DEVELOPMENT REVIEW BOARD
SUPPLEMENTAL SUBMITTAL

PROJECT NO. 2022-006547

Application No. SI-2022-00216

RE: Panda Express – S8-22-D8582
10126 Coors Blvd. NW
Albuquerque, NM 87114
RE: DRB Planning Review – 1st Resubmittal
DRB Project Number: 2022-006547
App. Number: SI-2022-00216

SITE PLAN VIEW - BUILDING AND STRUCTURE HEIGHT

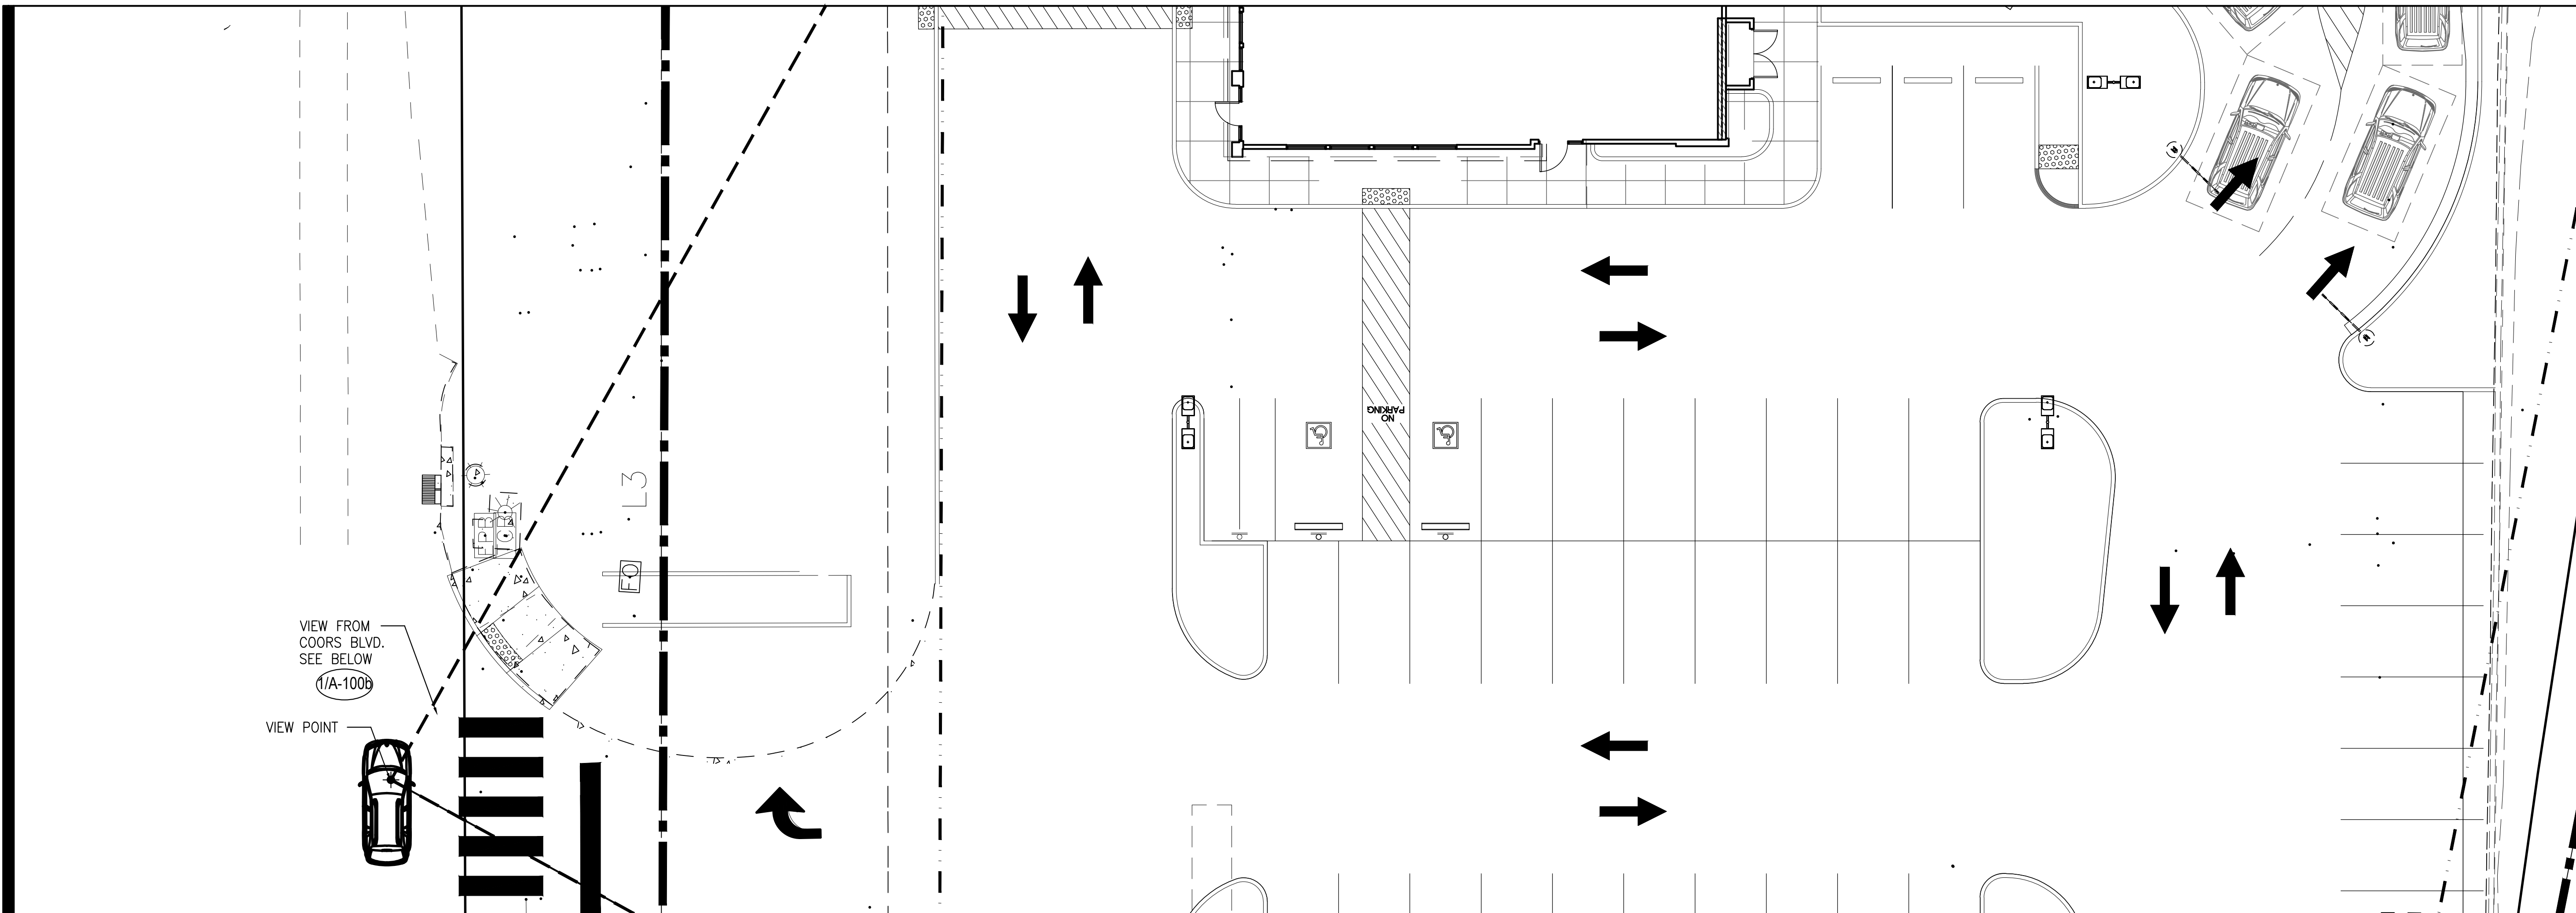
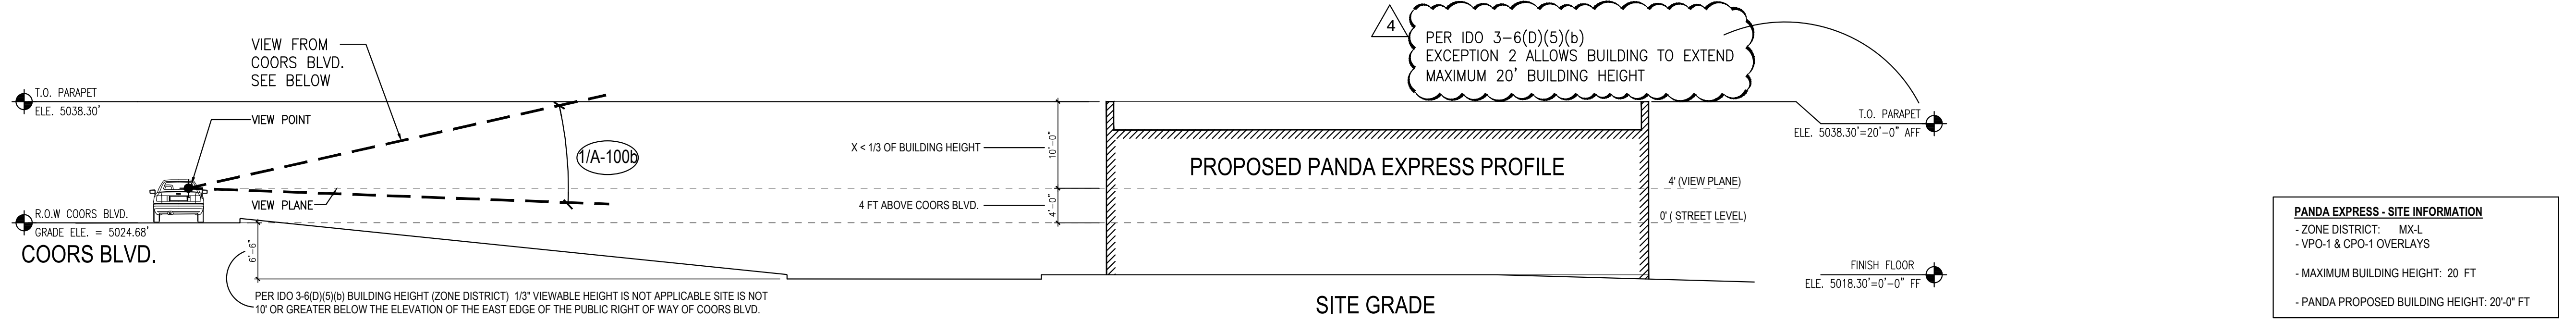
3. As per VPO-1, IDO 3-6(D), sight line/ view frame analysis & elevations will be needed if there is building on the Site Plan.

Response: Refer to sheet A-100 Site Plan for sight line/ view frame analysis.

C03.2

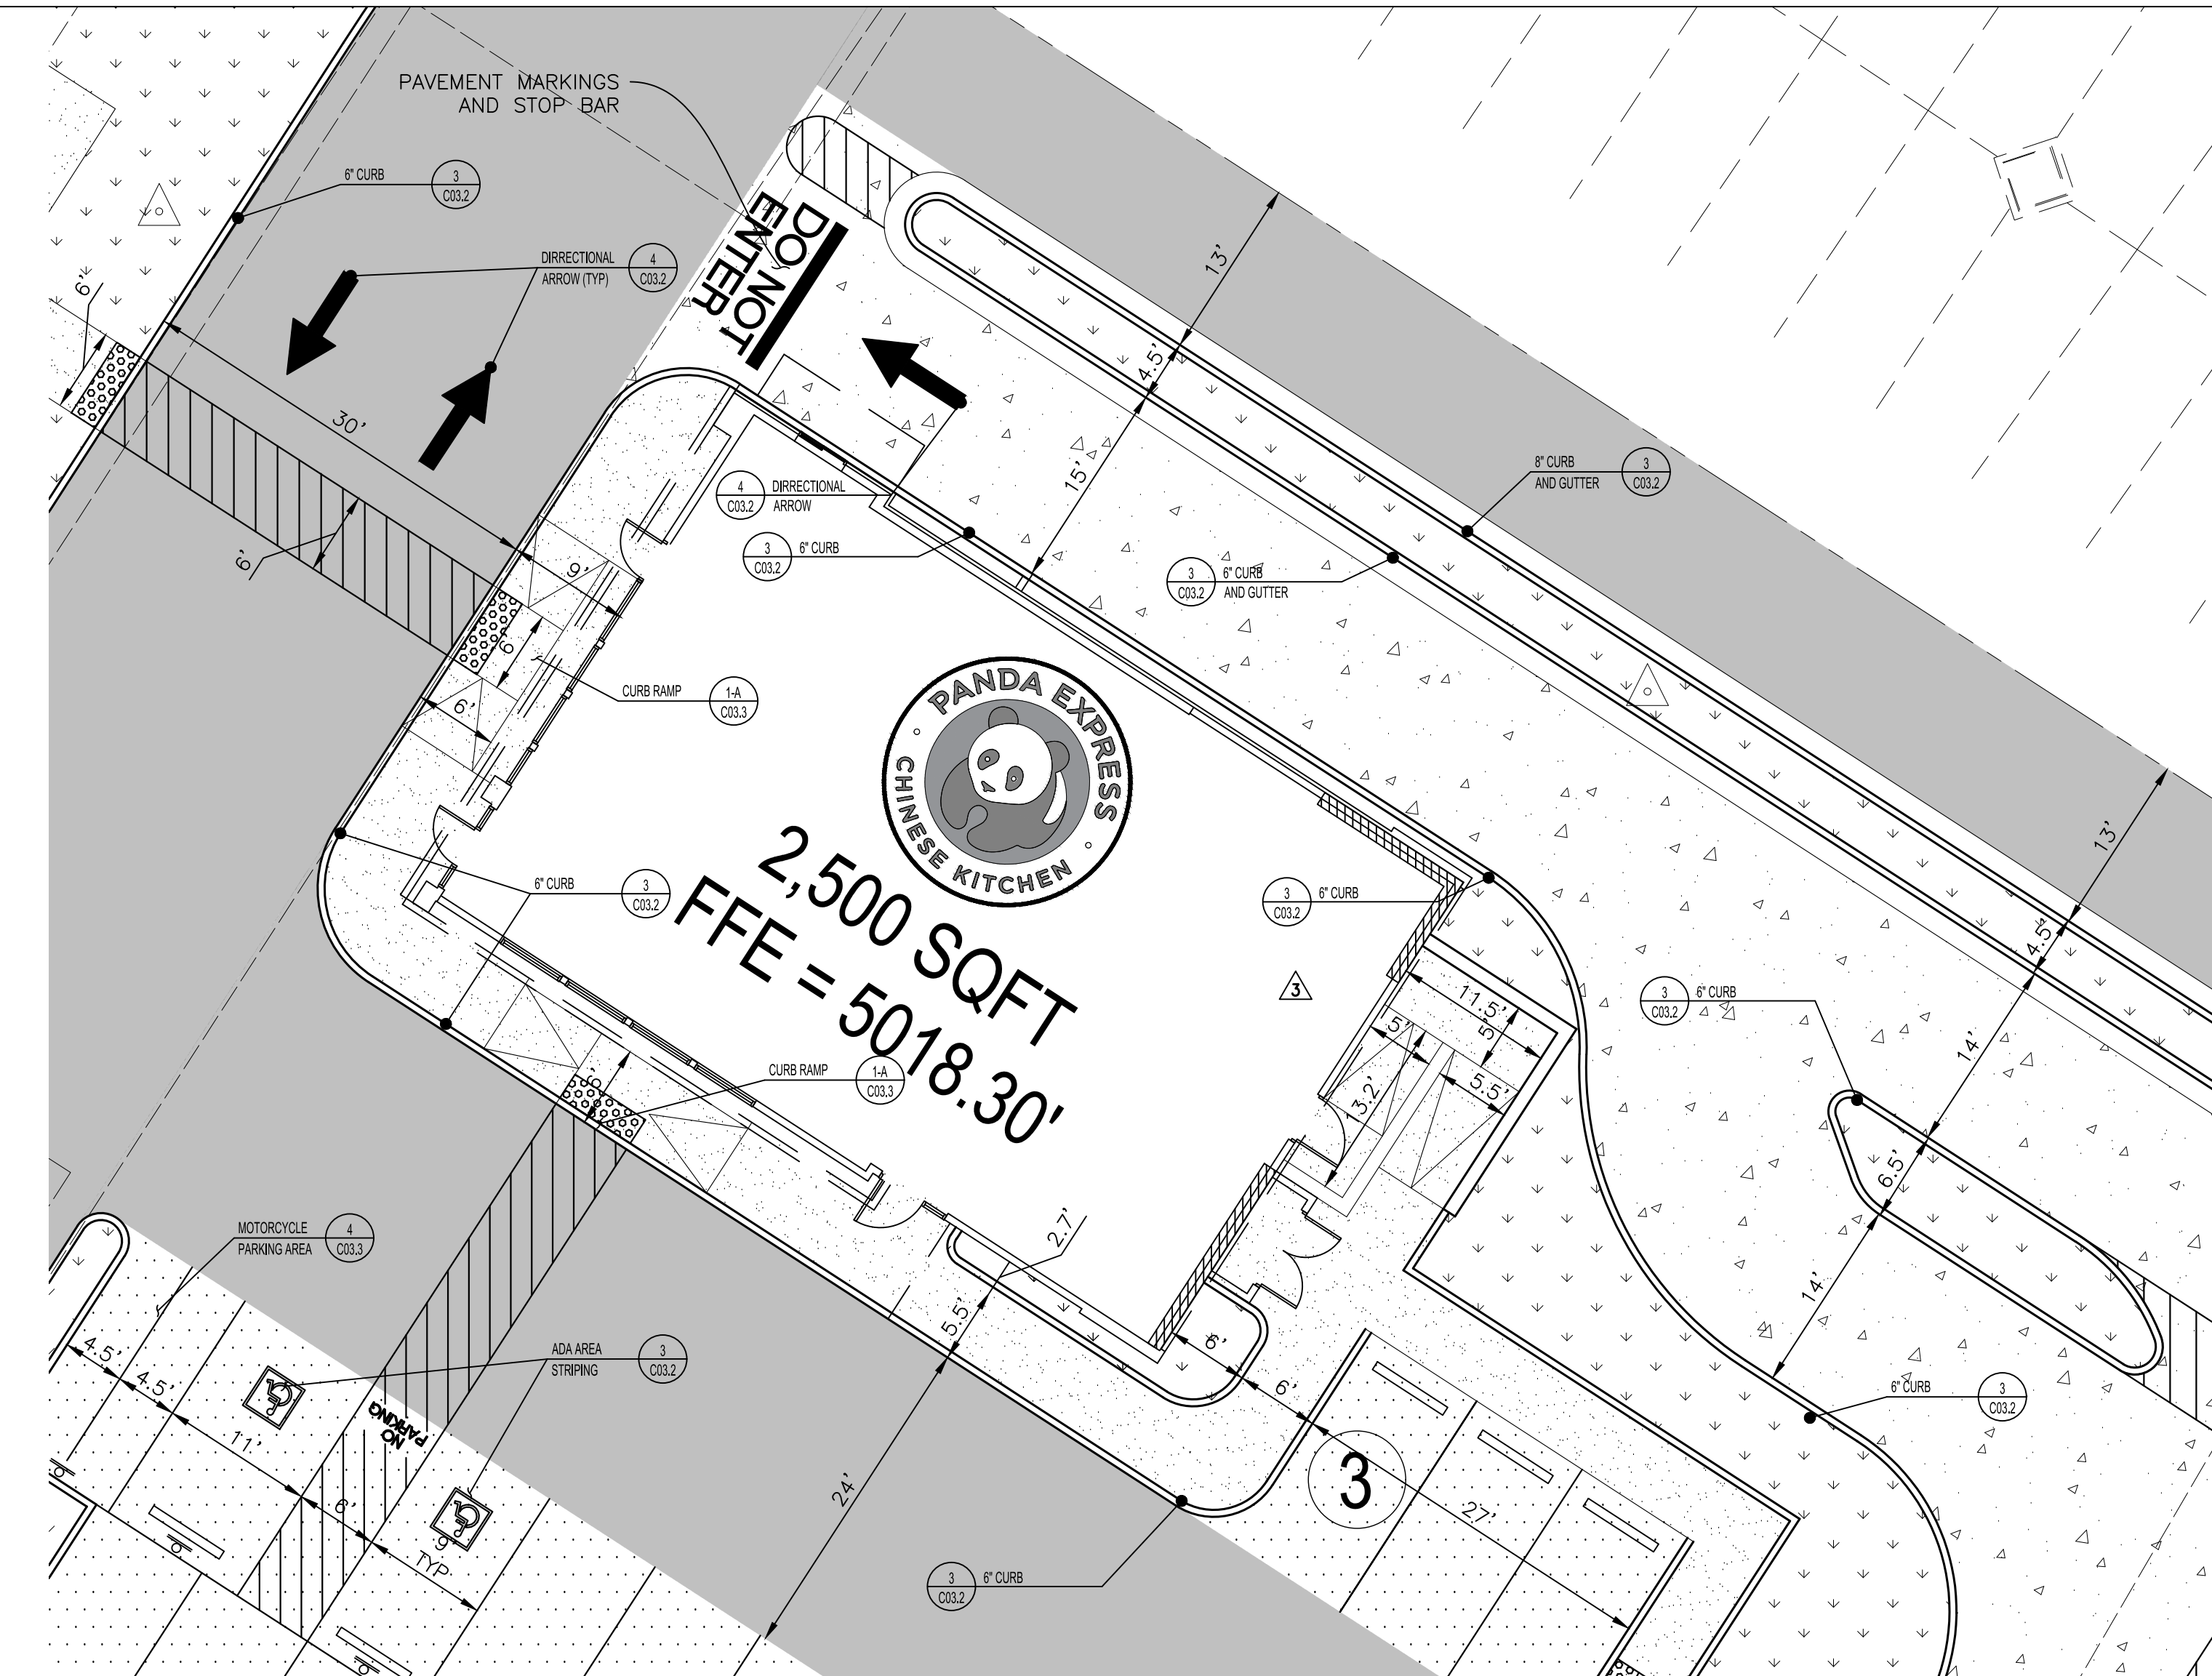
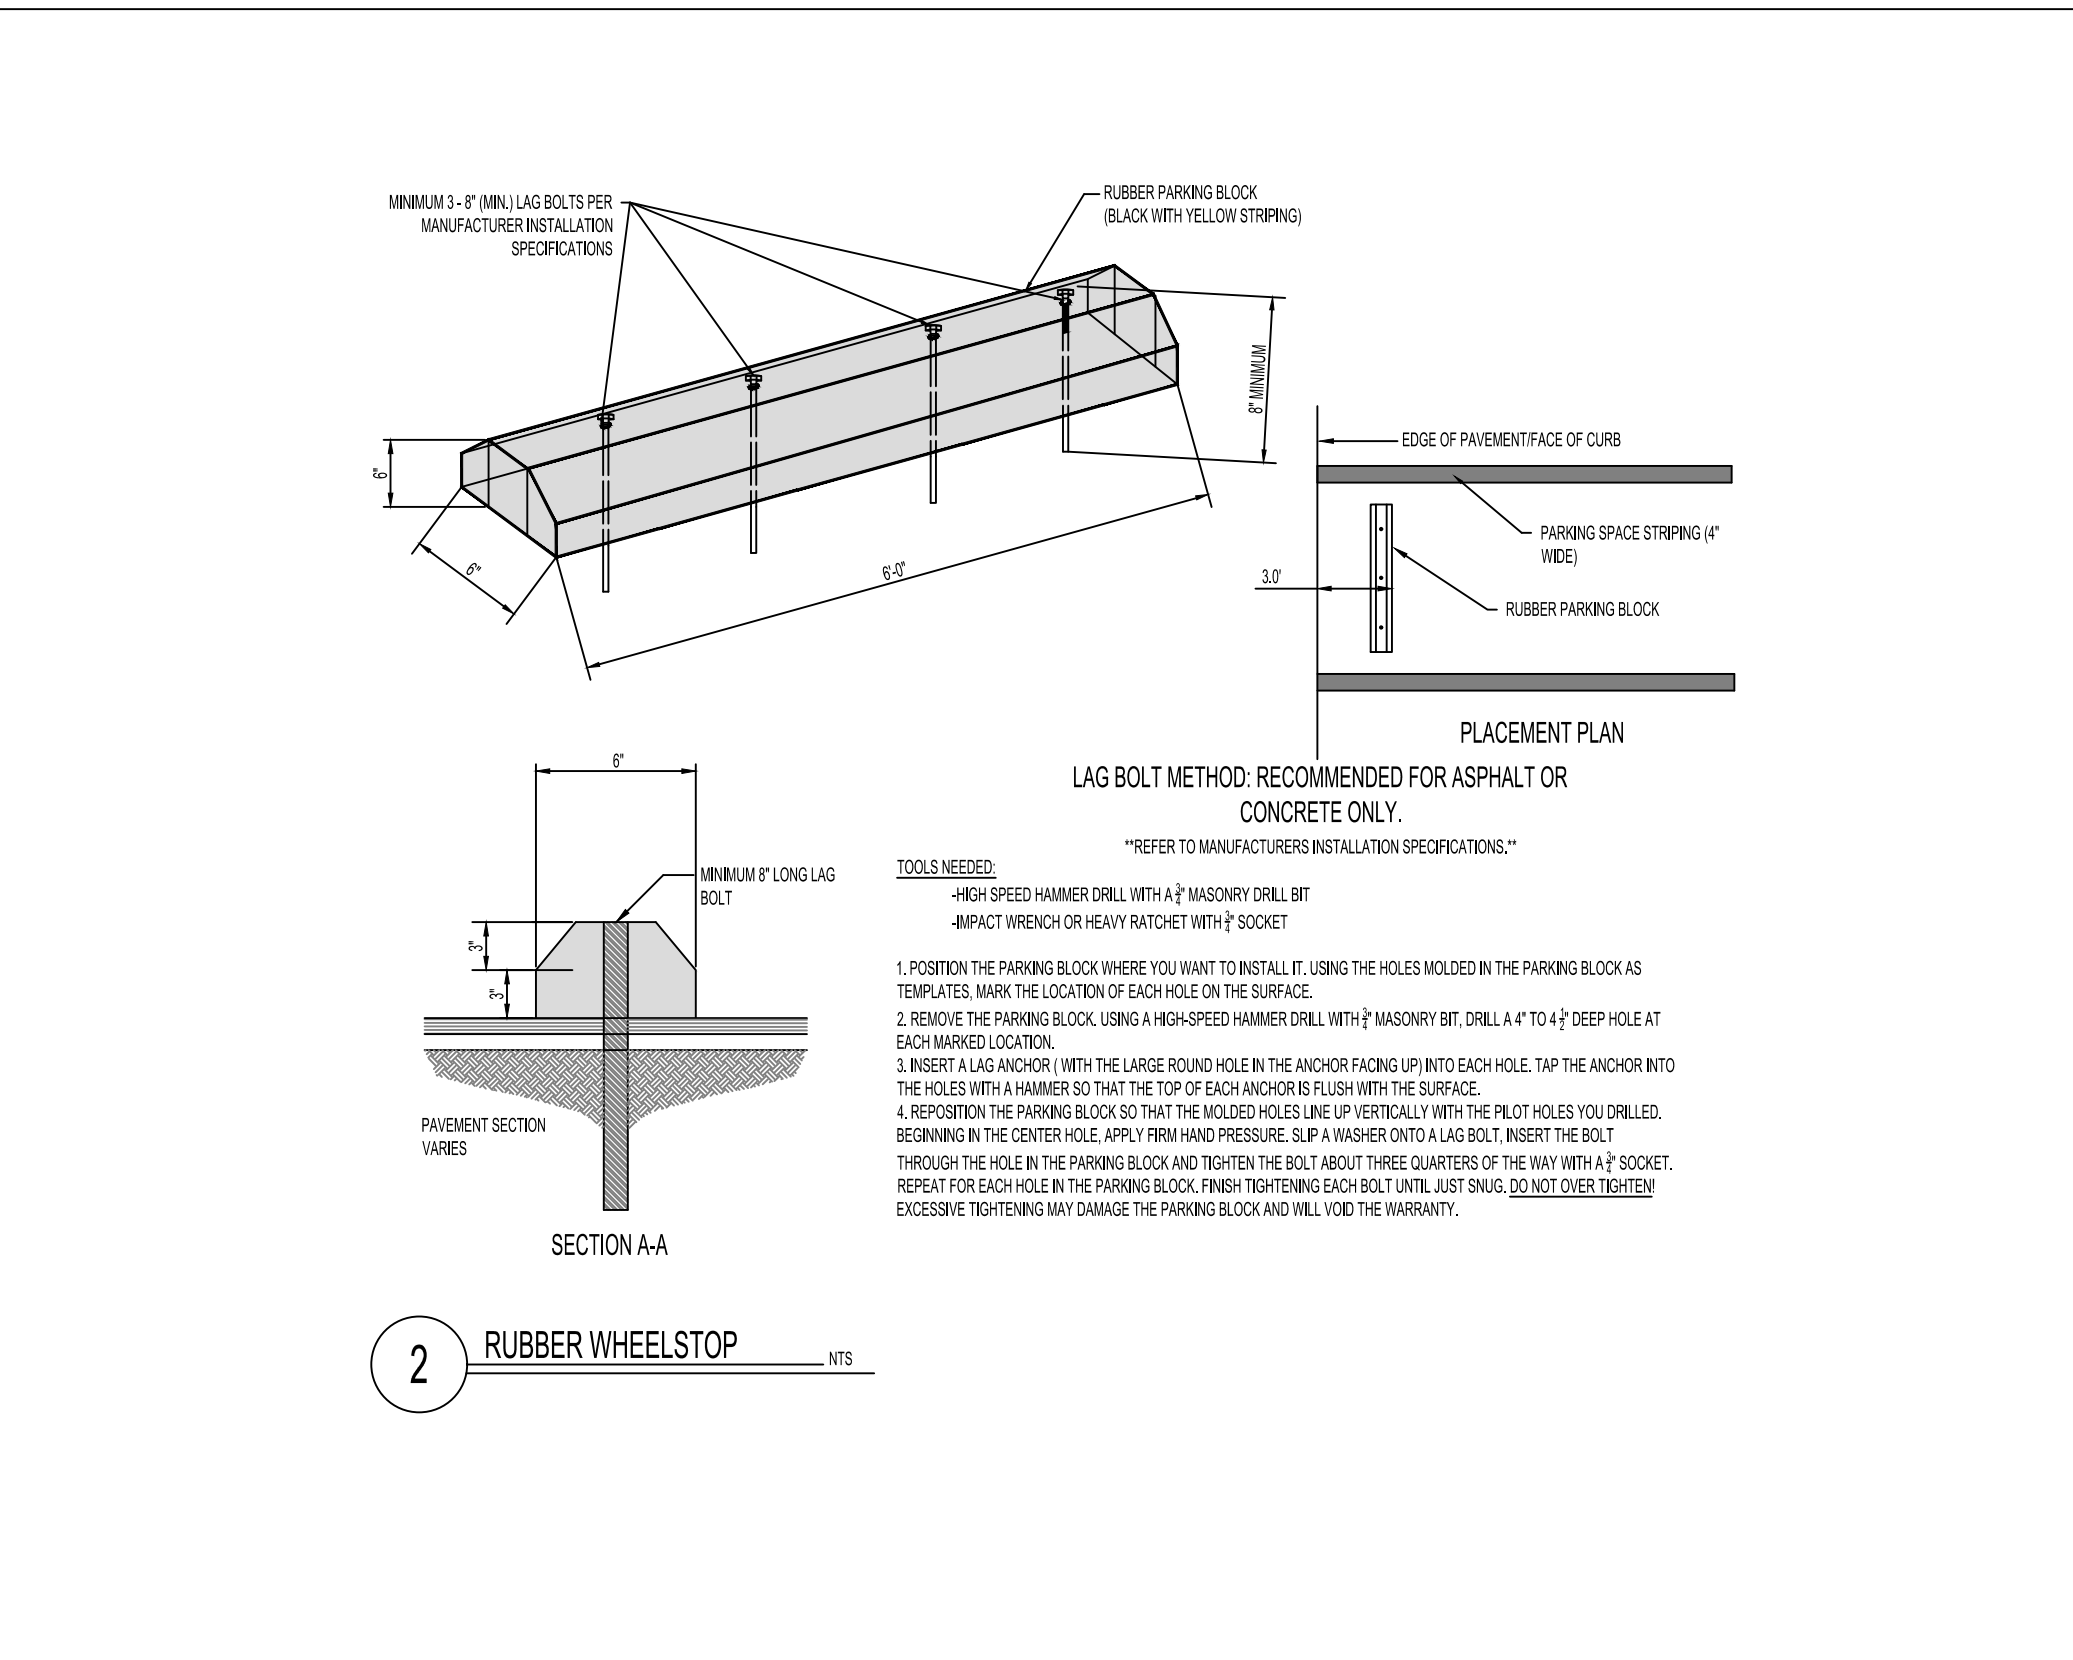
10. Provide handicapped signage details, and show "No Parking" on the pavement in the back of the van accessible aisle. Label handicapped spaces with a keyed note on the site plan.

Response: Refer to sheet C03.2 Hardscape Details I
